## **Response to Traffic Comment**

RE: Additional Response to Traffic Comments  
Queue Observations  
Applicant - J. B. Brown & Sons  
Proposed Hotel, Restaurant, and Residences  
321 Commercial Street, Portland, Maine  
MMI #5002-01-4

DATE: 10-22-12  
 SCALE: 1"=20'  
 DRAWN BY: BJS  
**C04**  
 SHEET: 4 OF 14

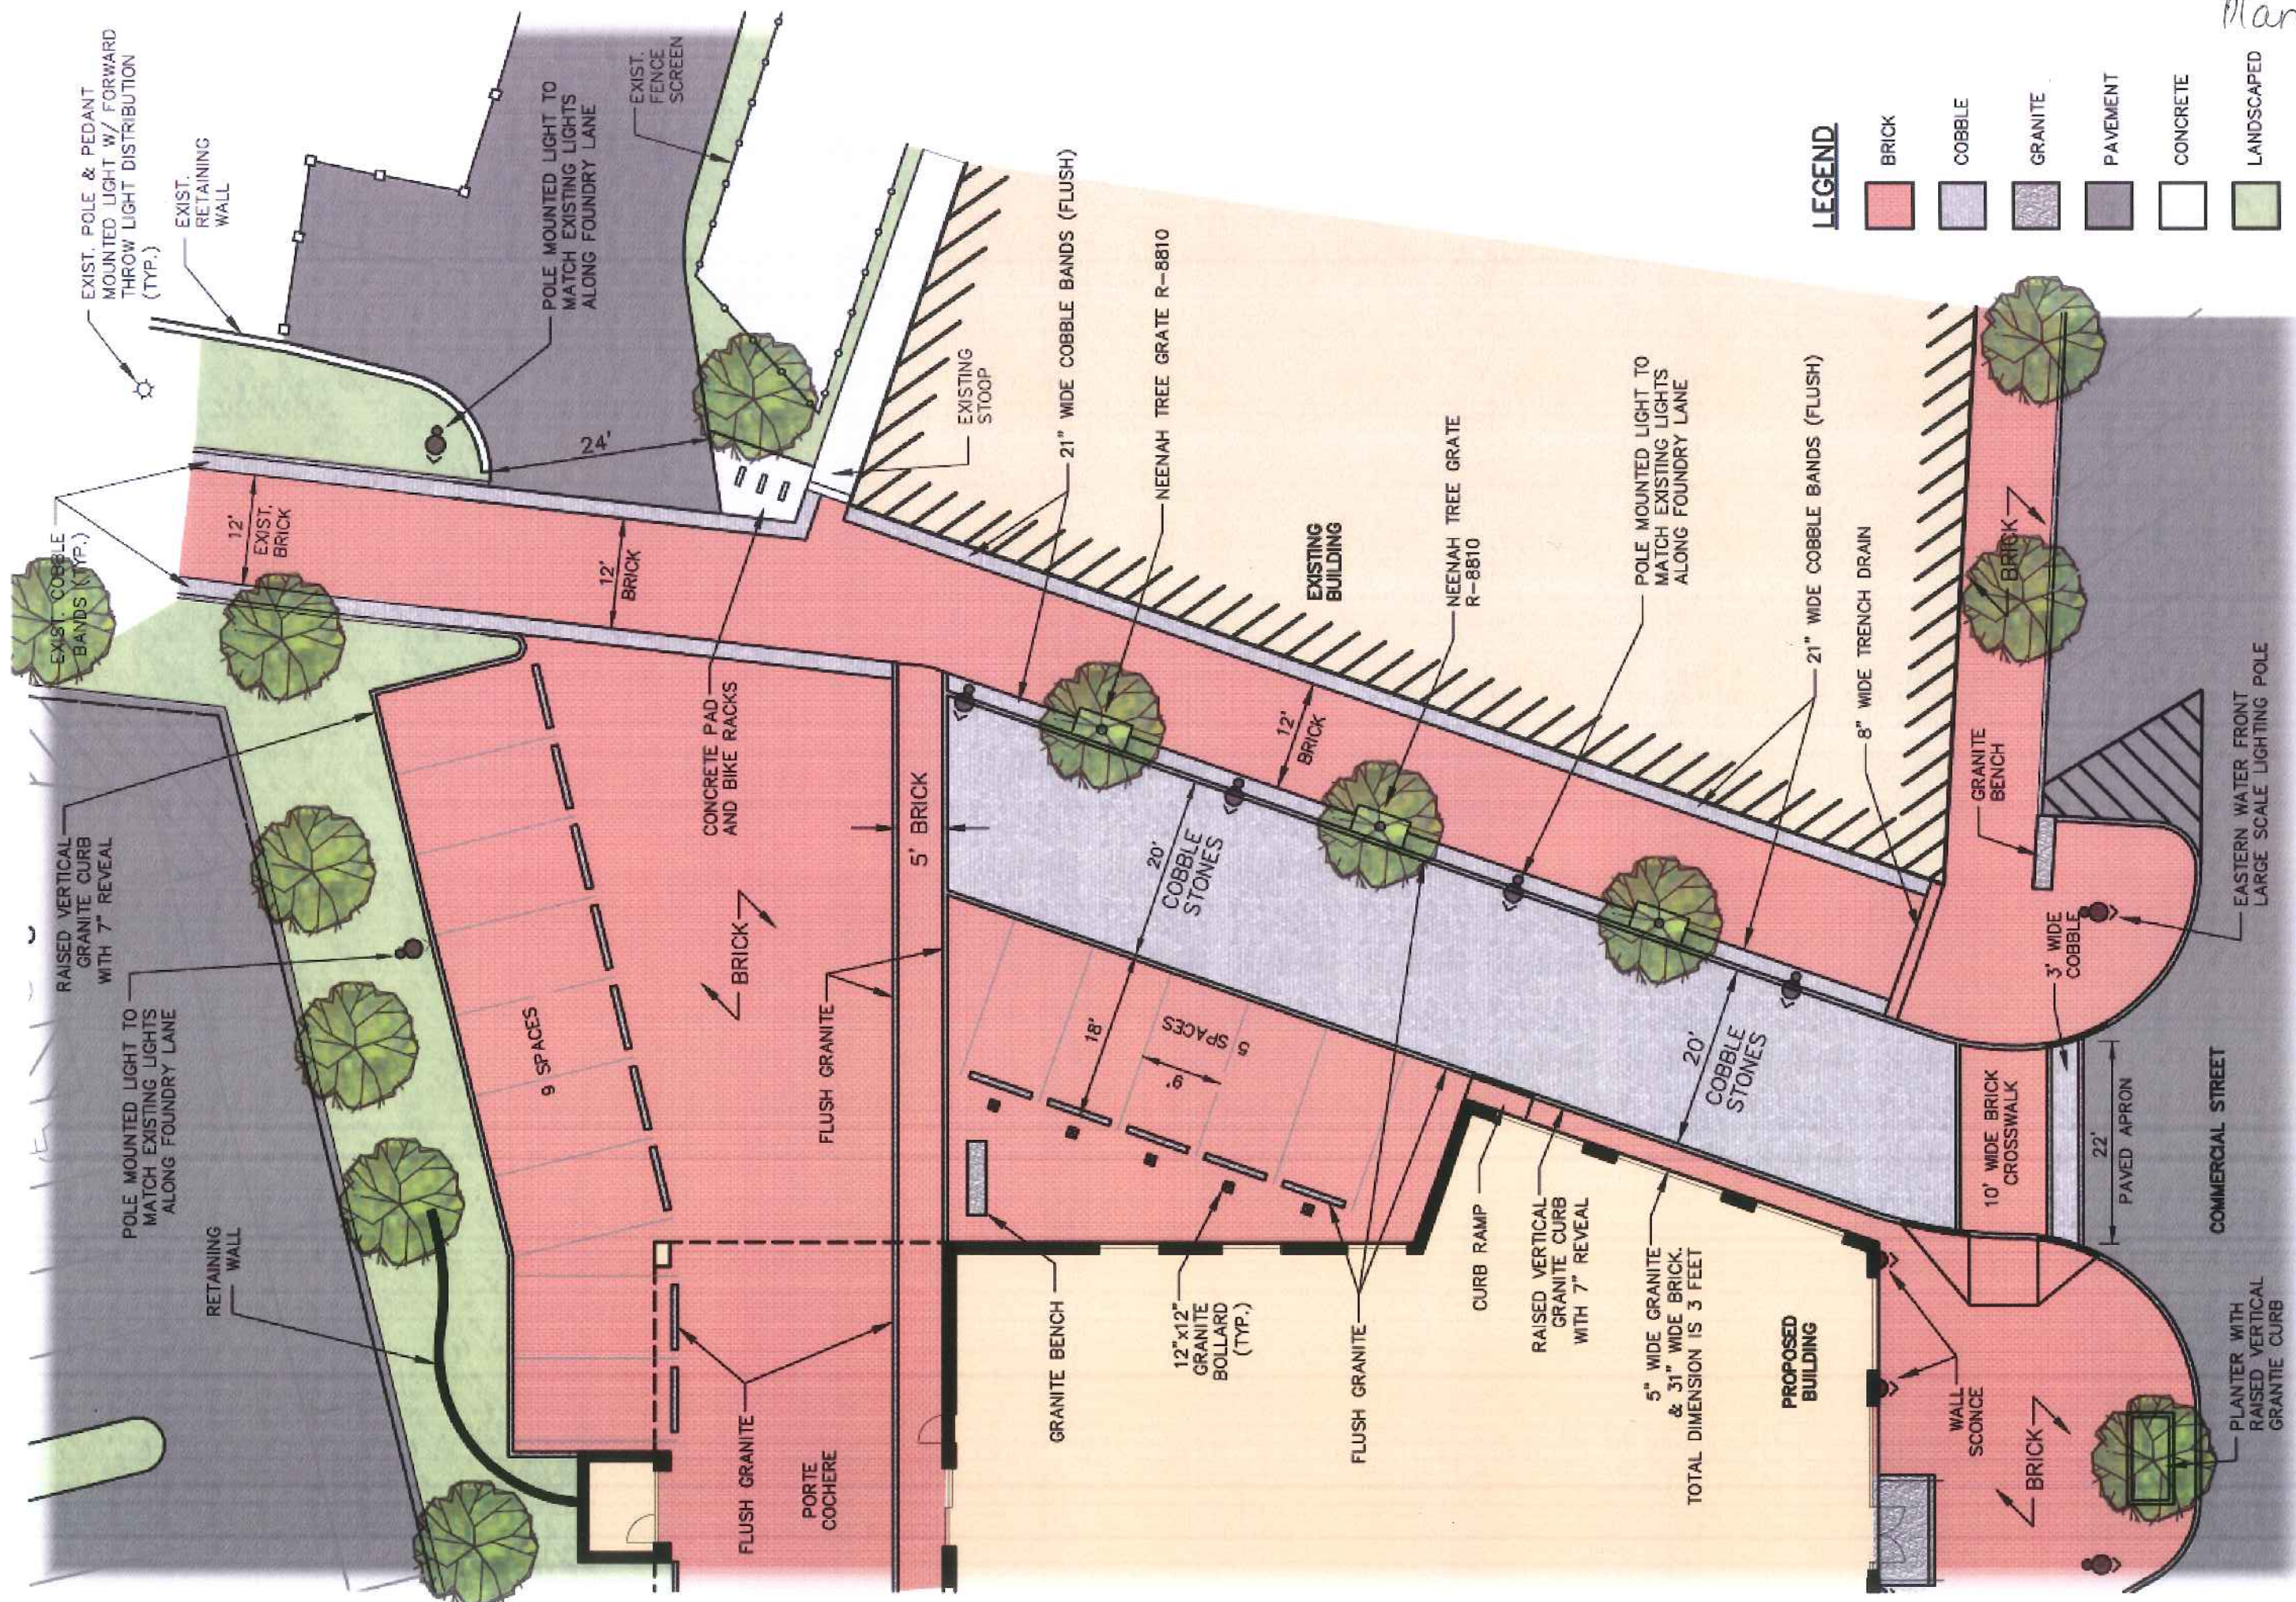
*Comment: The applicant should review and analyze the potential for the proposed Commercial Street entrance to be blocked by queuing from the adjacent signalized intersection of Commercial Street at Center Street.*

Response: The applicant has reviewed and analyzed the potential for the Commercial Street entrance to be blocked by queuing from the adjacent signalized intersection. The proposed Commercial Street entrance is an existing Street (Foundry Lane) that is being utilized as a full-access entrance for the proposed mixed-use development. The entrance is located approximately 150 ft west of the intersection of Commercial Street at Center Street. To determine the potential for blocking by queues from the adjacent signalized intersection, staff from Milone & MacBroom (MMI) made field observations during the weekday AM and PM peak hours. These peak hours were identified when traffic counts were taken as part of the Traffic Movement Permit application. The traffic counts identified the AM peak hour as 7:45-8:45 AM and the PM peak hour as 4:45-5:45 PM. The Queue observations were completed on December 19<sup>th</sup> and 20<sup>th</sup>.

In general, we found that the queue from the thru lane on Commercial Street occasionally blocked the entrance during our observations. The queue in the left-turn lane on Commercial Street did not block the entrance. Our observations indicated that a queue of approximately 7 to 8 cars would block the entrance. Our field observations are summarized in Table 1 attached at the end of this memo. The table

The results indicate that the site entrance was blocked during approximately ¼ of the signal cycles during the AM peak hour and approximately 1/3 of the cycles during the PM peak hour. Overall during the AM and PM observation hours the average queue was less than the 7 to 8 vehicles necessary to block the entrance. During the AM and PM peak hours of observation the site entrance was blocked 4.7 minutes and 6.5 minutes, respectively.

Based on the results of our Queue analysis it is our opinion that the site entrance will function adequately during the AM and PM peak hours. During other portions of the day the queuing will generally be less than the queues observed during the peak hours. In addition, the majority of the vehicles (approx. 2/3) exiting the site on Commercial Street will be turning right. If there are times when left-turning vehicles experience excessive delays due to queuing there are several other options available to exit the site. These options include:
